Subject: FW: A/45/19/PL

A/45/19/PL

Demolition of existing buildings (car show room, workshops and Phares Courtledge) and erection of 19 dwellings, a convenience store, a community building, public toilets and associated car parking and landscaping

Street Scene Elevation - Facing onto High Street

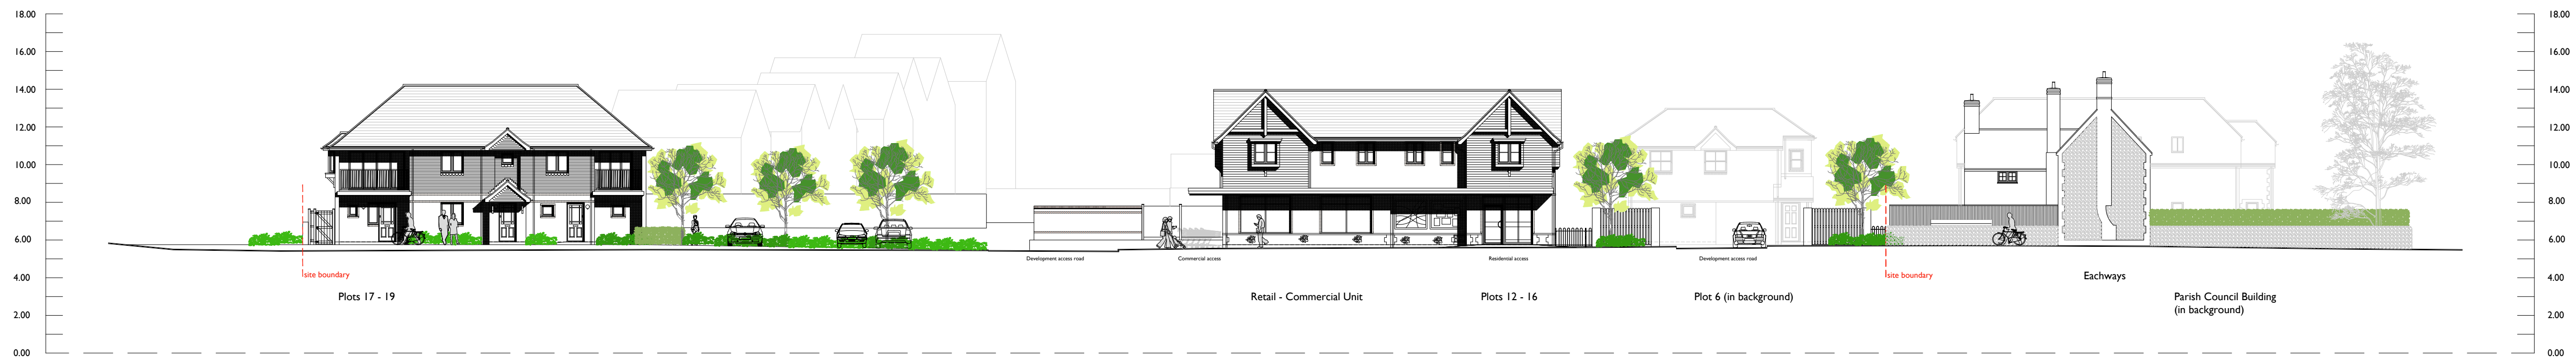
Plot 1-4 are all the same, whereas plot 5 is a different design. It is not clear why this is the case. Plot 5 is more complex in appearance with a number of half hip dormers on a small section of the front elevation. The building is also an unusual shape, having an angled floor plan. It is not clear why this is required. It is suggested that this front elevation and floor plan could be simplified so that it reflects the other buildings which it forms a group with.

The retail unit is very closely located to Eachways. It is considered to be substantial in size, with a complex roof form that does not fully reflect the character of the properties in the surrounding area (including the conservation area). Development of this building could be considered to be harmful to the listed building.

Likewise, the Parish Council building is located close to Eachways and projects forward of it. I note that this building is attempting to emulate the previously lost barn style buildings, with the DAS stating that *'the overall building elevation treatment is based around a 'converted barn' style of development with additional development and uses materials to highlight the design principles involved.* However, it is not clear from the plans provided if it would successfully pull off such a scenario.
